KITITAS COUNTY

MEMORANDUM

TO: All Staff
FROM: Public Works Plan Review Team
DATE: October 23, 2025
SUBJECT: AU-25-00009 Bollinger

SITE PLAN

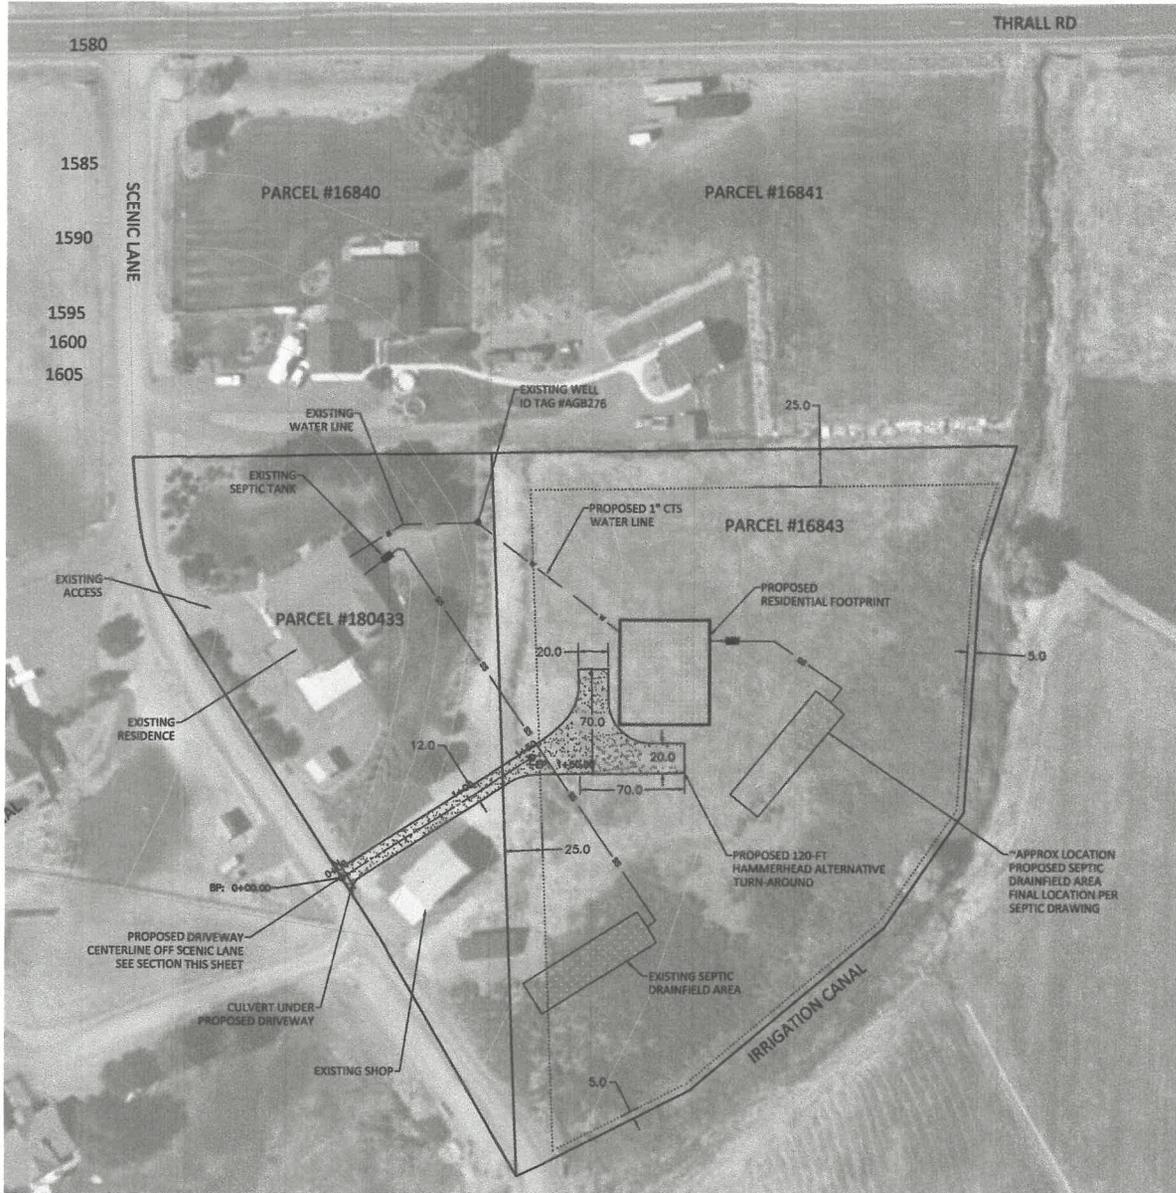
ACCESS	<ol style="list-style-type: none"> 1. An approved access permit shall be required from the Kittitas County Department of Public Works prior to creating any new driveway access or altering an existing access. 2. Private Road Certification required for Scenic Ln. 3. KCC Title 12.04.07.060 requires a minimum 30' easement for a shared residential driveway. 4. Maintenance of driveway approaches shall be the responsibility of the owner whose property they serve. The County will not maintain accesses. 5. Any further subdivision or lots to be served by proposed access may result in further access requirements. See Kittitas County Road Standards. <p>In addition to the above-mentioned conditions, all applicable Kittitas County Road Standards apply to this proposal. Access is not guaranteed to any existing or created parcel on this application. (RC)</p>
ENGINEERING	Except as exempted in KCC 14.05.060, no grading or filling upon a site involving more than one hundred (100) cubic yards shall be performed without a grading permit from the County Engineer or Public Works designee (KCC 14.05.050). An application for grading in excess of five hundred (500) cubic yards shall be accompanied by an engineered grading plan (KCC 14.05.080). (CBP)
